Ribble Valley Borough Council
By email

Your ref 3/2026/0313
Our ref DC/26/1421
Date 17-JUN-26

Location: Springwood Drive Whalley BB7 9XL Phase 2 Lawsonsteads
Proposal: Approval of details reserved by conditions 15 (water mains protection) on planning permission 3/2021/0760.

Further to our review of the submitted information, United Utilities does not feel sufficient information has been provided at this time, therefore we recommend that Condition 15 is **NOT discharged**.

DRAWING:  
**Proposed Plan & Elevation**

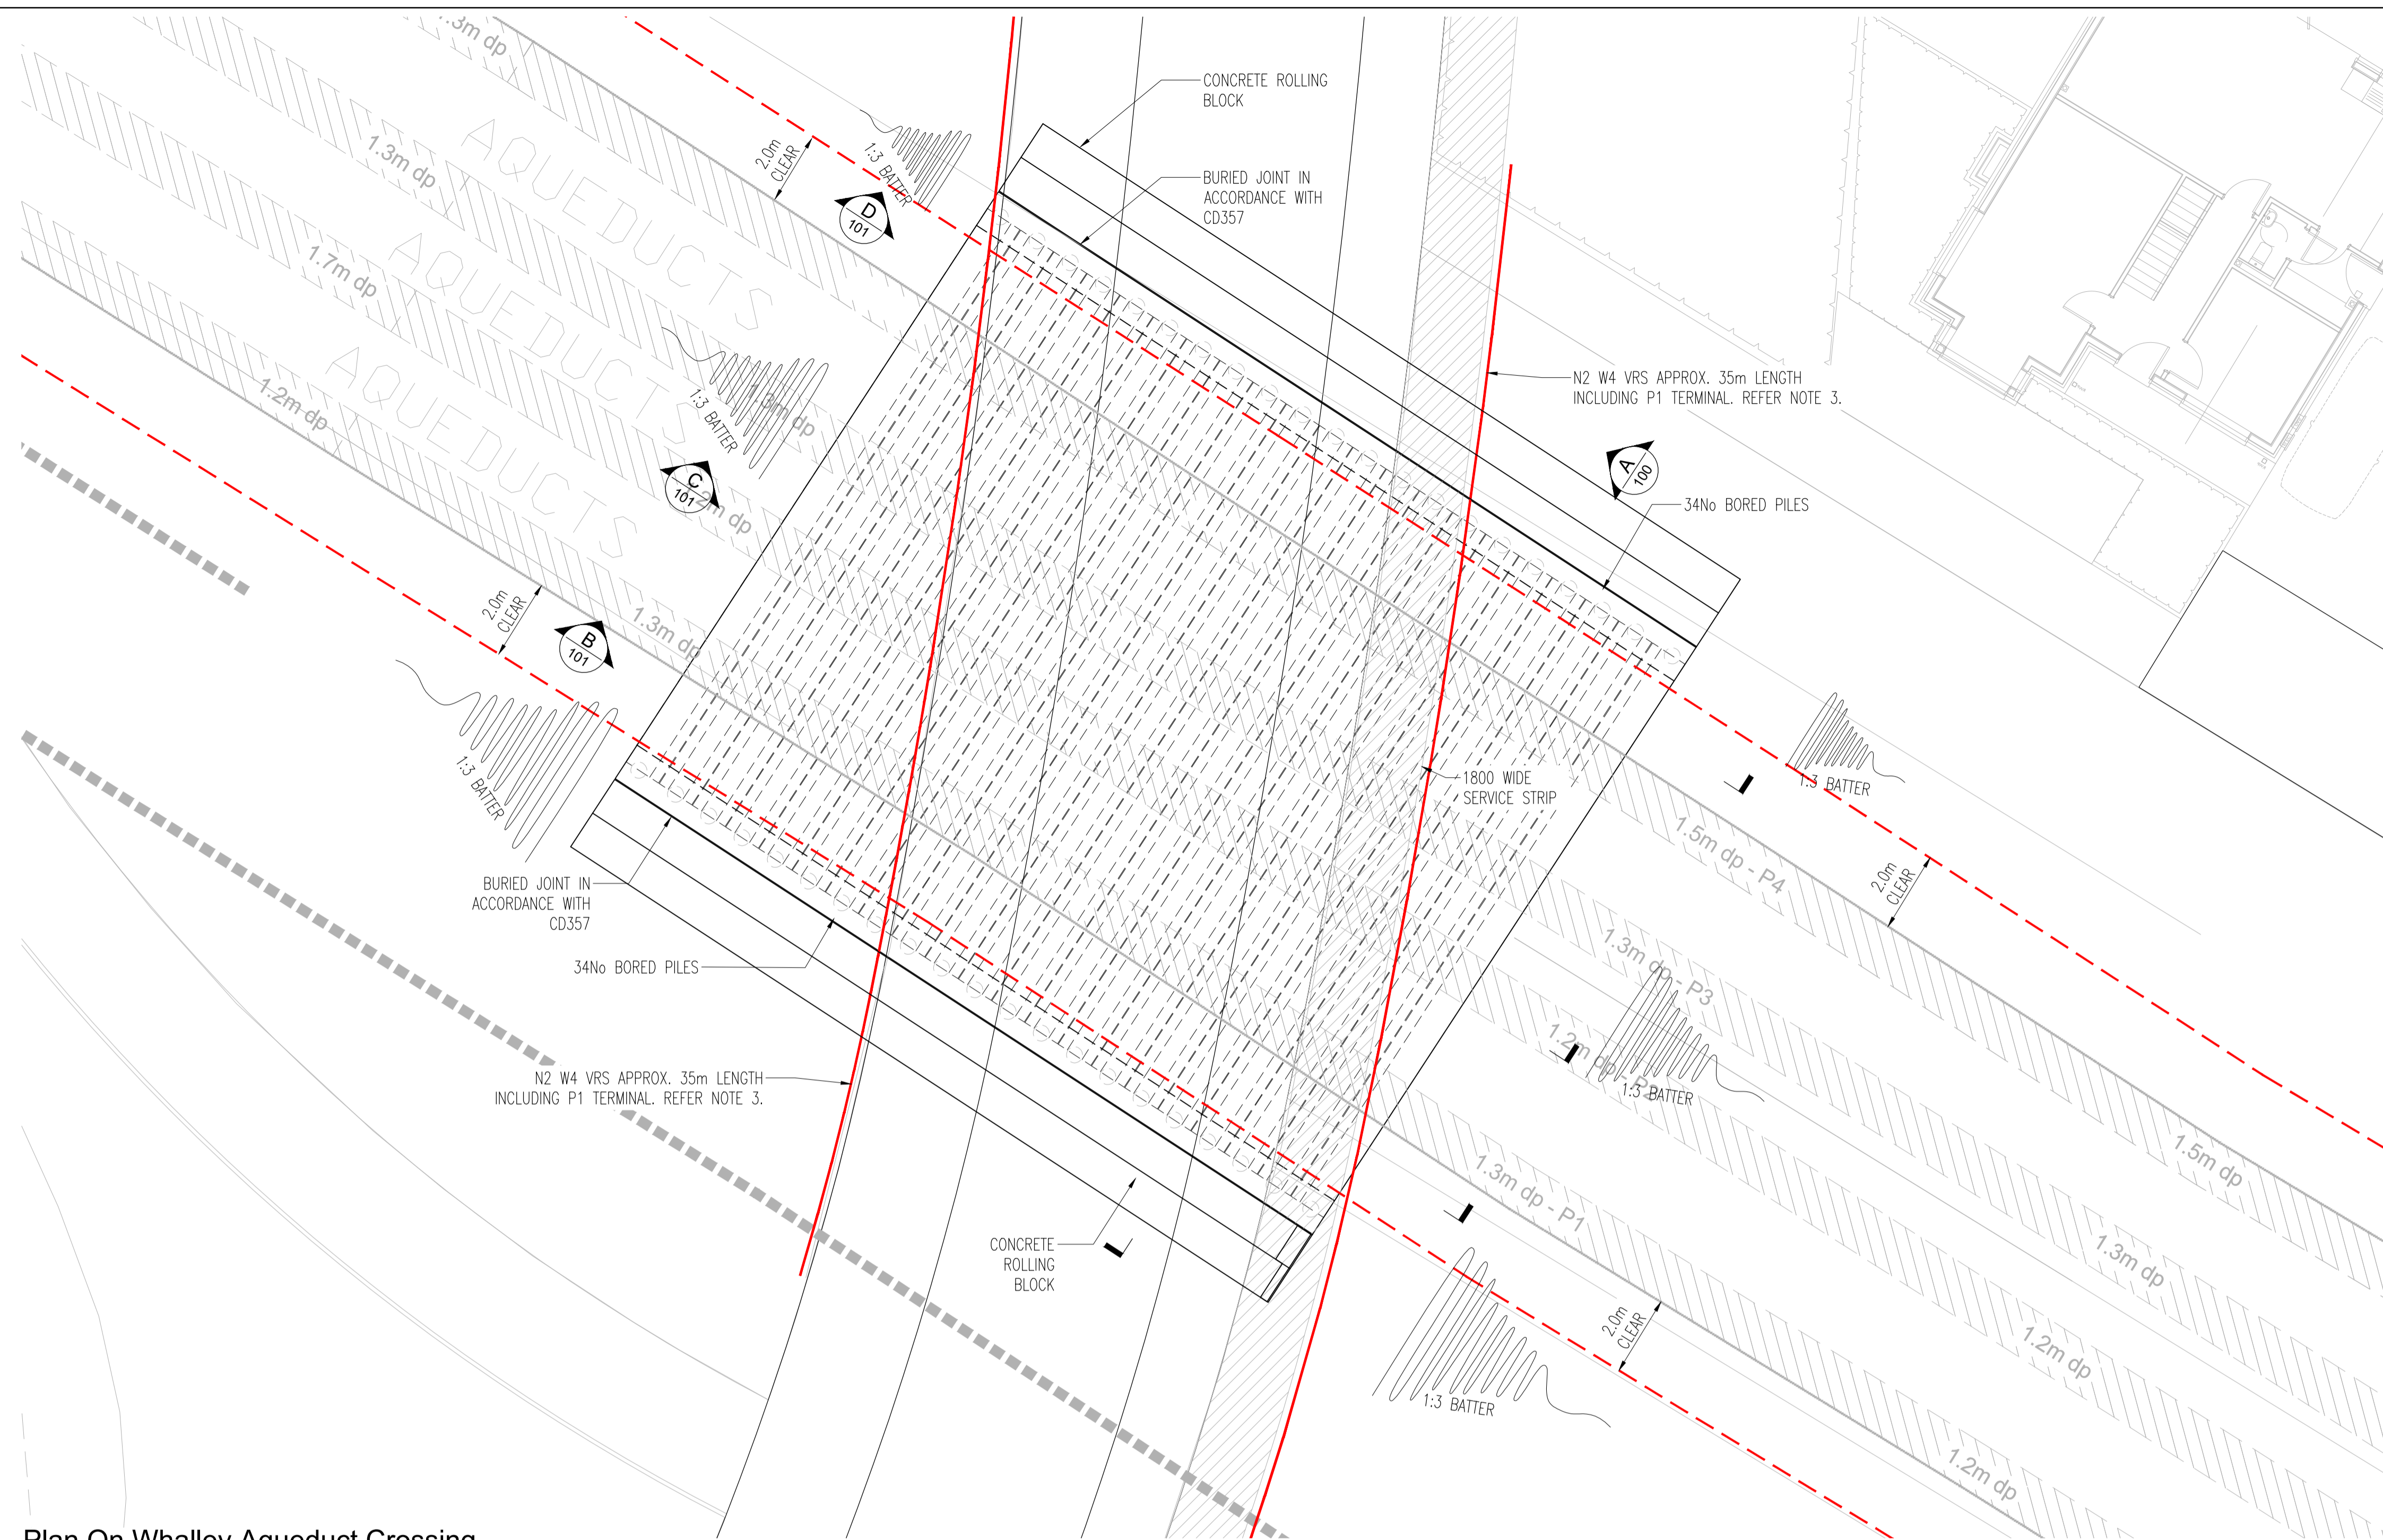
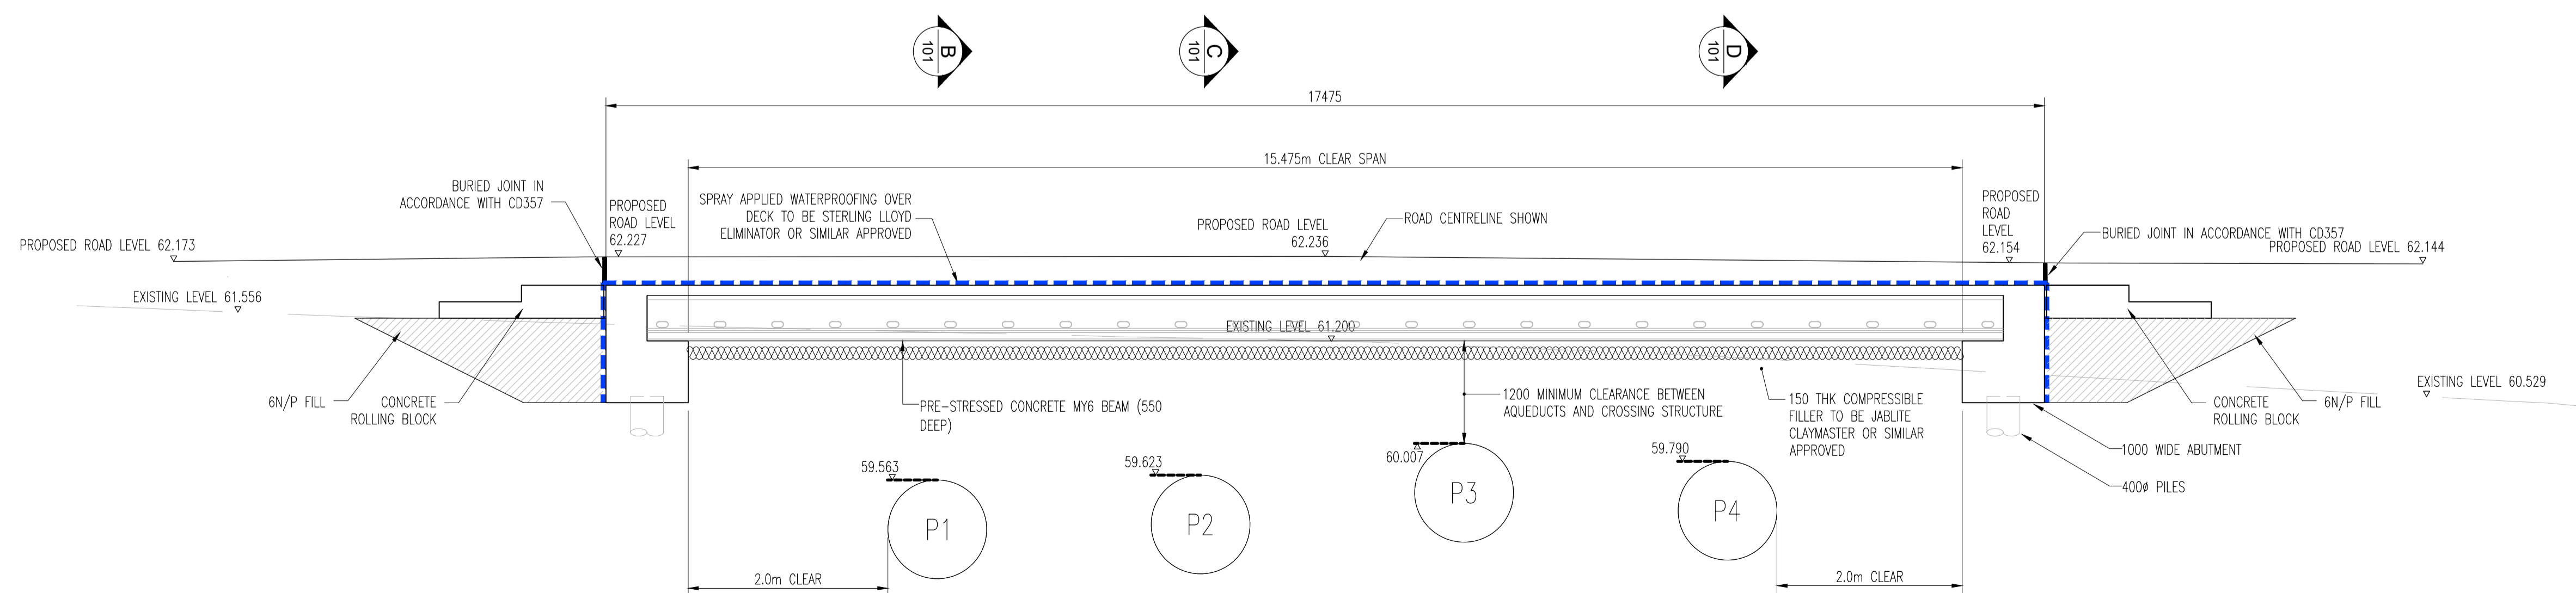
- *The temporary protection measures and the loading pressures underneath the pad;*
- *evidence that the ovality/deflection and buckling stability of the steel is within allowable limits set out in BS9295. In addition, the equivalent analysis for the rigid pipe / concrete main as per BS9295; and*
- *modelling of the soil stresses and ground settlement.*
